Case Officer: Lewis Knox

Recommendation: Approve

Proposal: Relocation of existing timber outbuilding and erection of single and two storey extension to side and rear of existing dwelling

dra. no.  
2069/03<sup>A</sup>

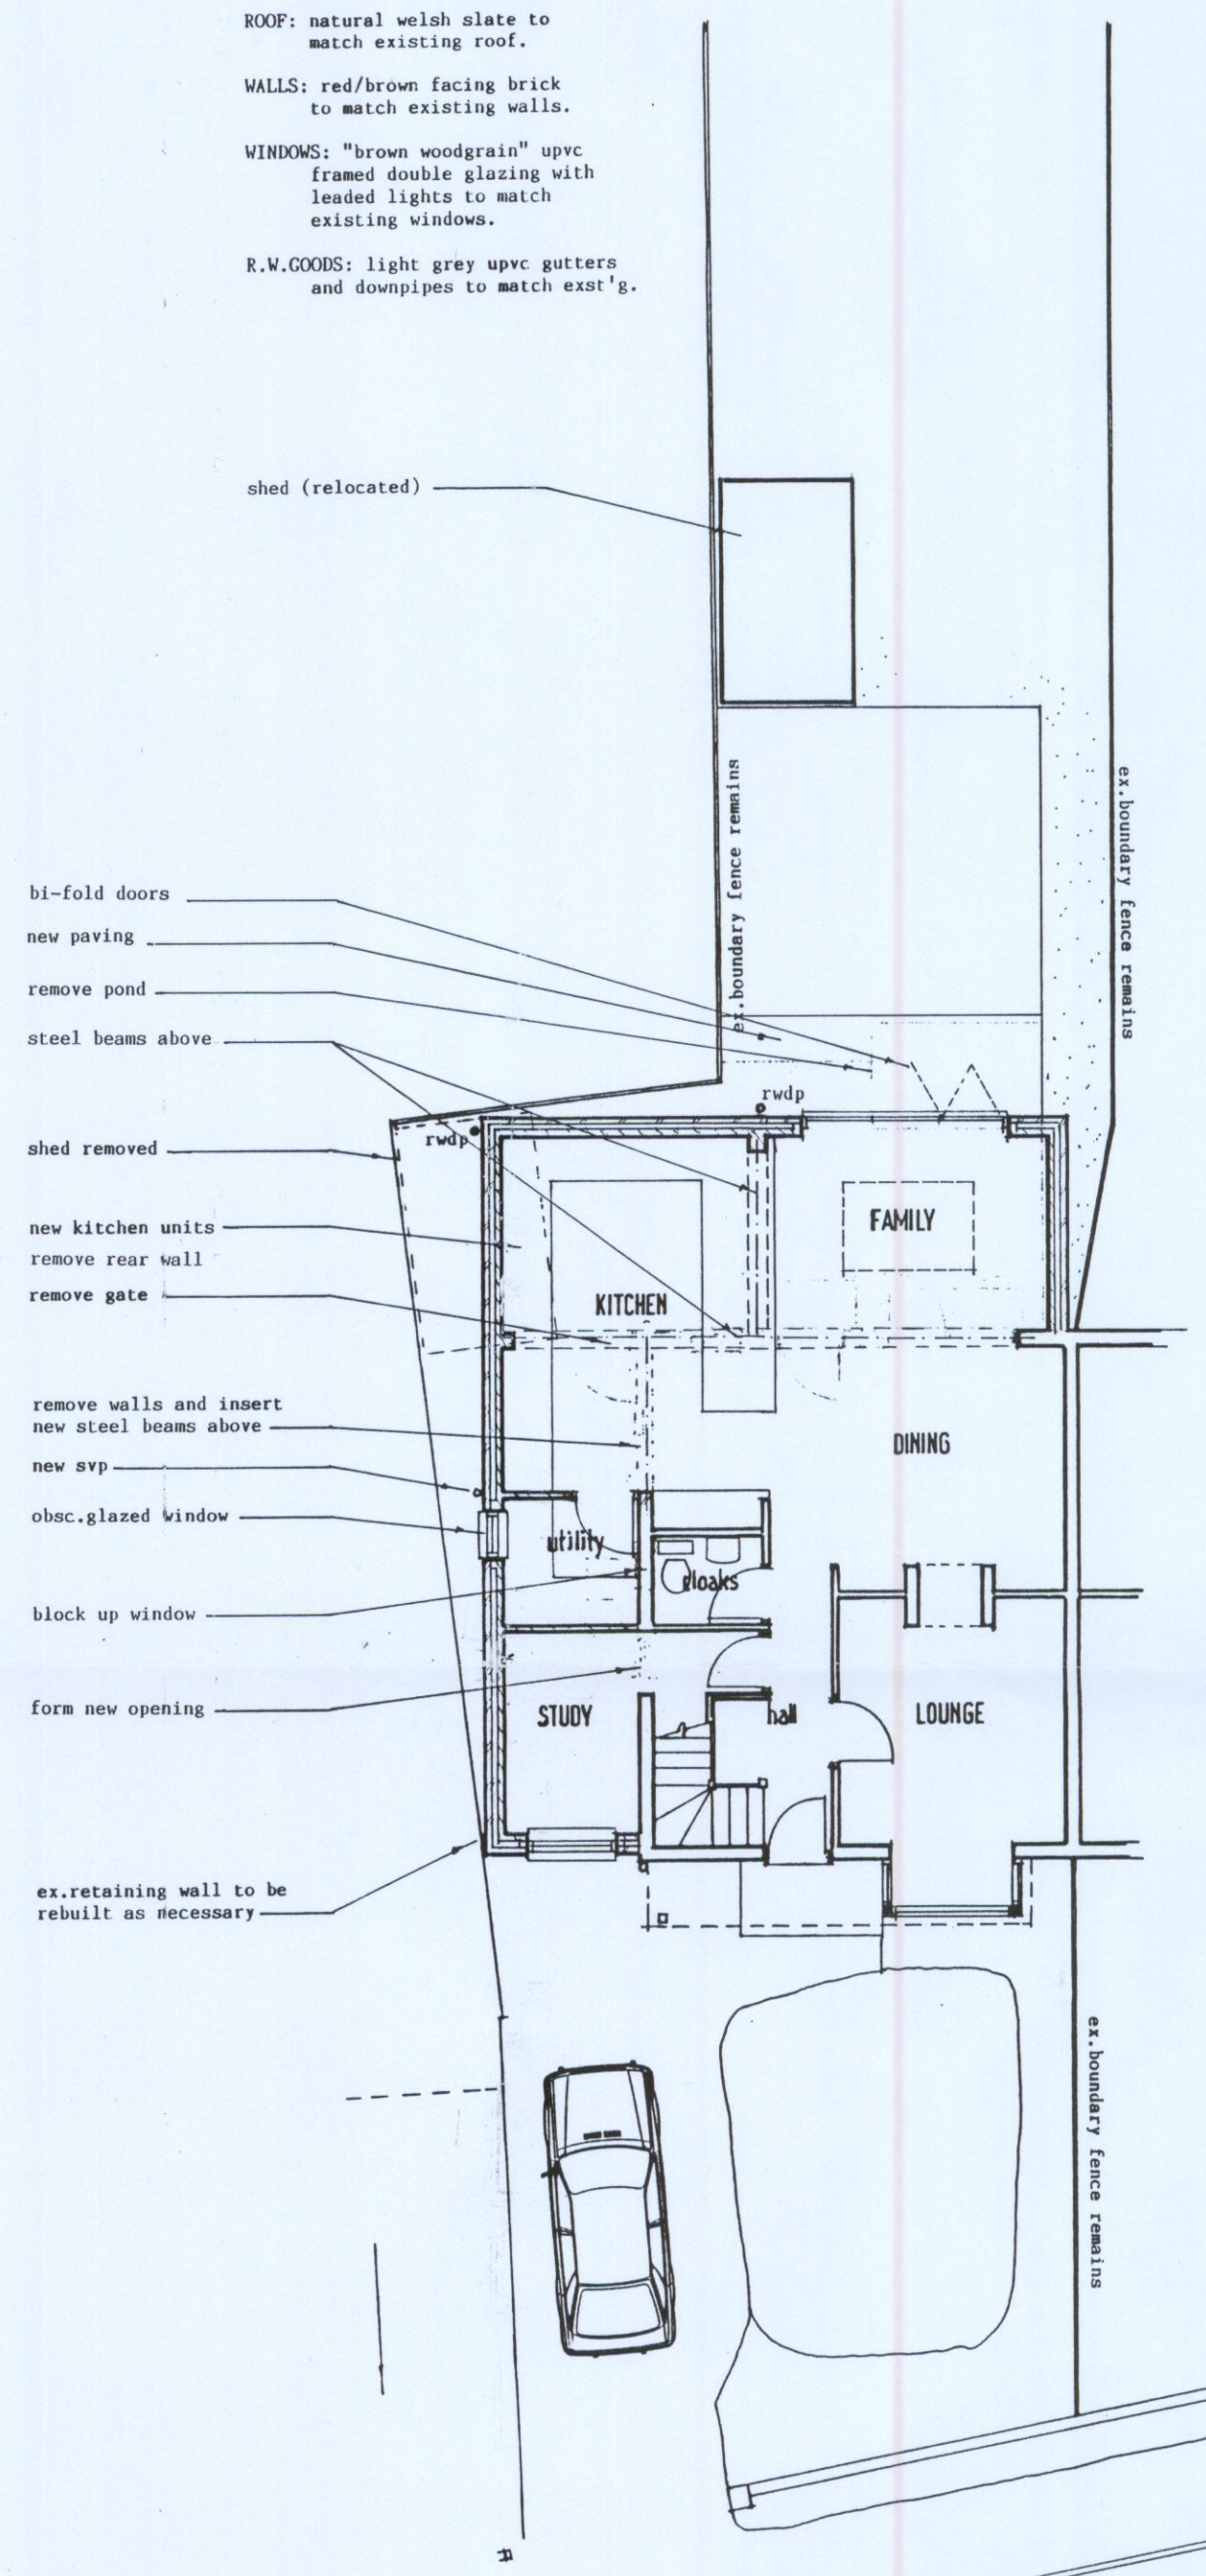
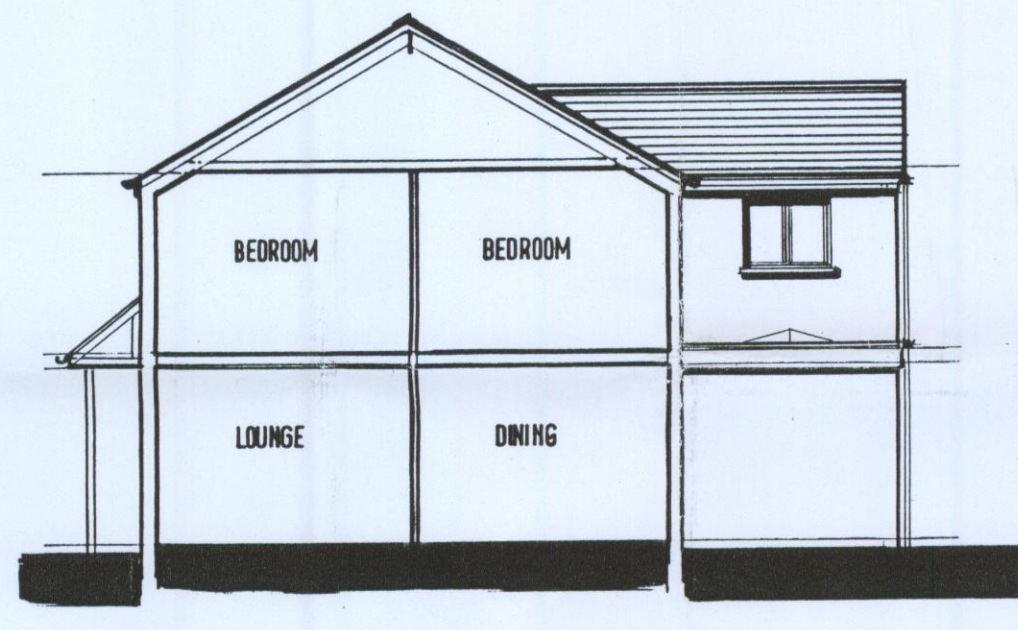
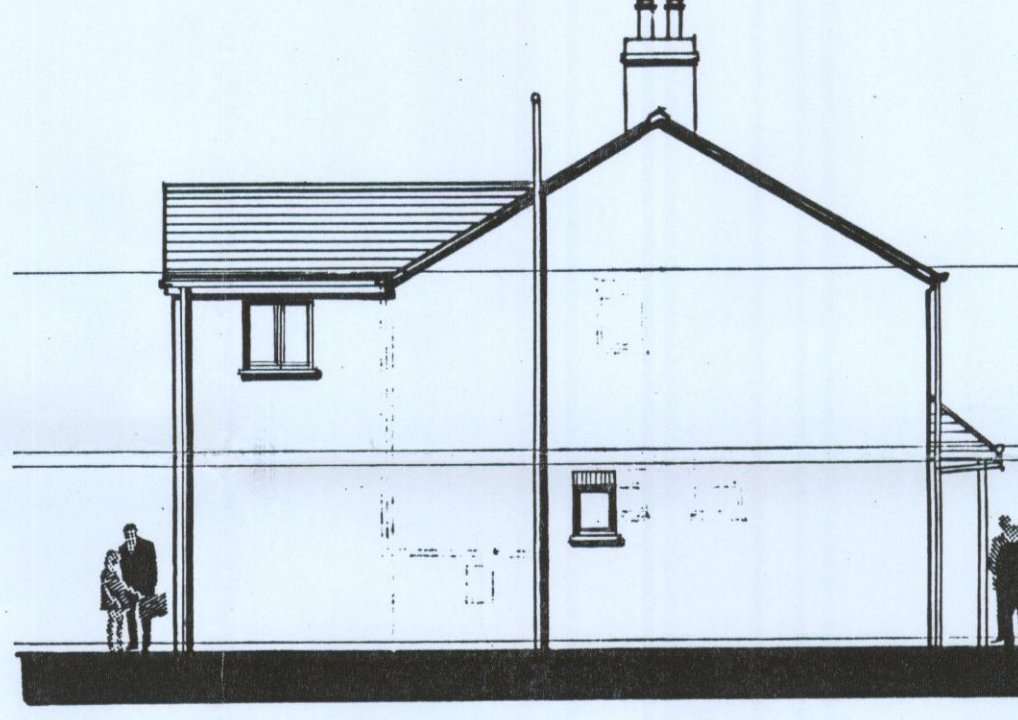
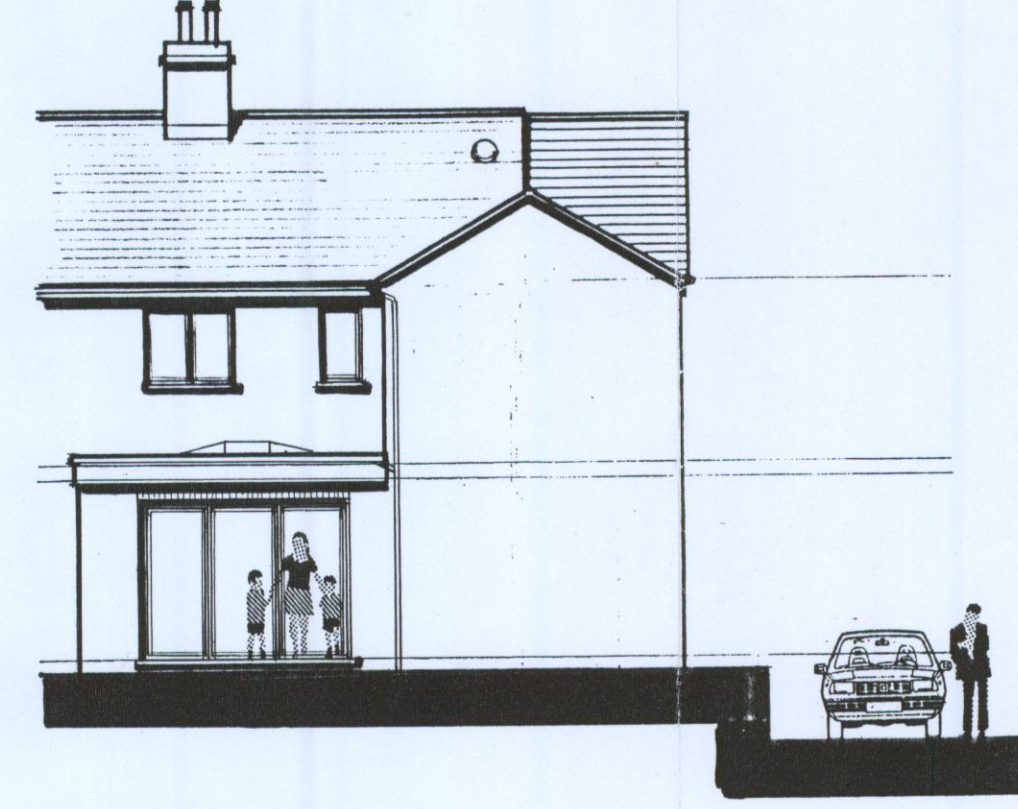
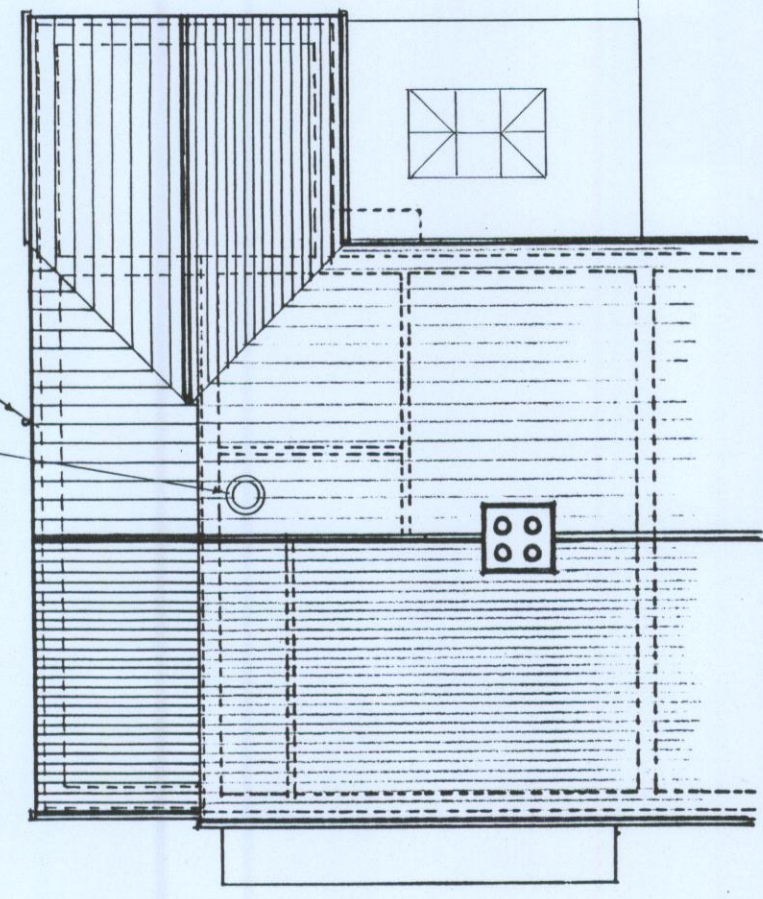
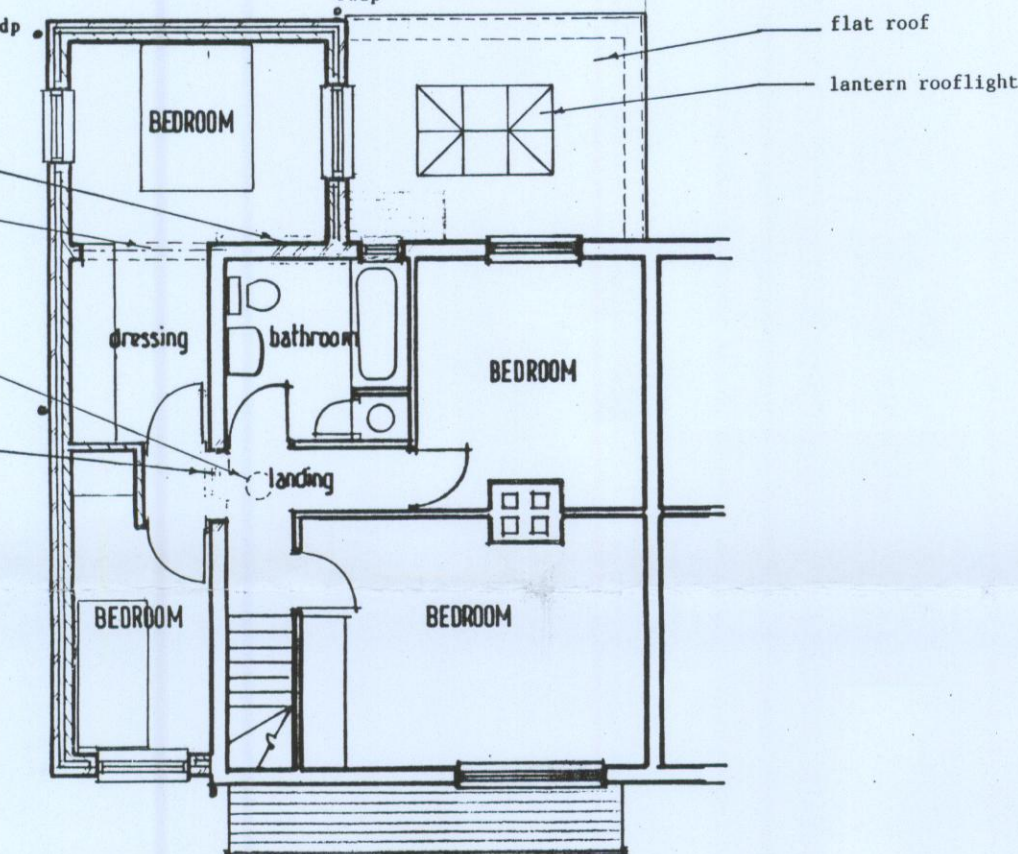
- 8.7. The submitted plans show subservience to the main dwelling with the proposed ridge line being set down from the ridge line of the original dwelling as well as the front elevation of the extension set back from the front of the application dwelling. These are welcome details and allow the extension to not appear overly dominant within the streetscene and allows the original dwelling to be read when viewed from the public domain.

- 8.15. The element of the extension which would extend beyond the rear elevation of the application dwelling would be in line with the lower lying neighbour to the eastern side. There is one window on the western elevation which would face toward the development. The separation distance would only be approximately 8.0m. However, it is considered that there would only be a loss of light to this window in the late evening and would not sufficiently impact to warrant a refusal of the application on this basis.

- 8.16. The facing window to the eastern elevation would serve a bedroom and could result in a loss of privacy to the neighbouring dwelling given the small separation distance. It is considered necessary and reasonable to impose a condition on any permission to require this window to be fixed shut and obscurely glazed. This bedroom would also be served by a window on the western elevation and so sufficient light to the room would be retained. The lack of objection from the affected neighbour has been given some weight in this assessment.

- 8.17. The element of the extension which would be closest to the attached neighbour to the west would be flat roofed and single storey and so would not impact on the amenity of the first floor windows. The single storey element would be less than 3.0m in depth and would have a similar impact to a single storey extension which could be achieved through permitted development. It is not considered that this element would detrimentally impact on the amenity of the attached neighbour.

- 8.18. The two storey element of the rear extension would be sufficiently away from the boundary with the attached neighbour and so would not conflict with the 45 degree rule to the upper floor windows and so would not impact in terms of loss of light, loss of outlook or overbearing. This element would include a western facing window which would face towards the boundary with the attached neighbour; it would be set off of the boundary by 4.0m with the single storey element between, it is considered that there would be some view into the neighbouring garden however the angle of view and the extent of the garden which would be visible would be minimal. It is not considered that this opening would significantly impact on the levels of privacy between the neighbouring dwellings.

3. The window in the second floor eastern elevation shall be obscure glazed, using manufactured obscure glass that is impenetrable to sight, (not an applied

adhesive film) before the extension is first occupied and shall be permanently retained as such thereafter. The window shall also be non-opening, unless those parts which can be opened are more than 1.7m above the floor of the room in which it is installed and shall be permanently retained as such thereafter.
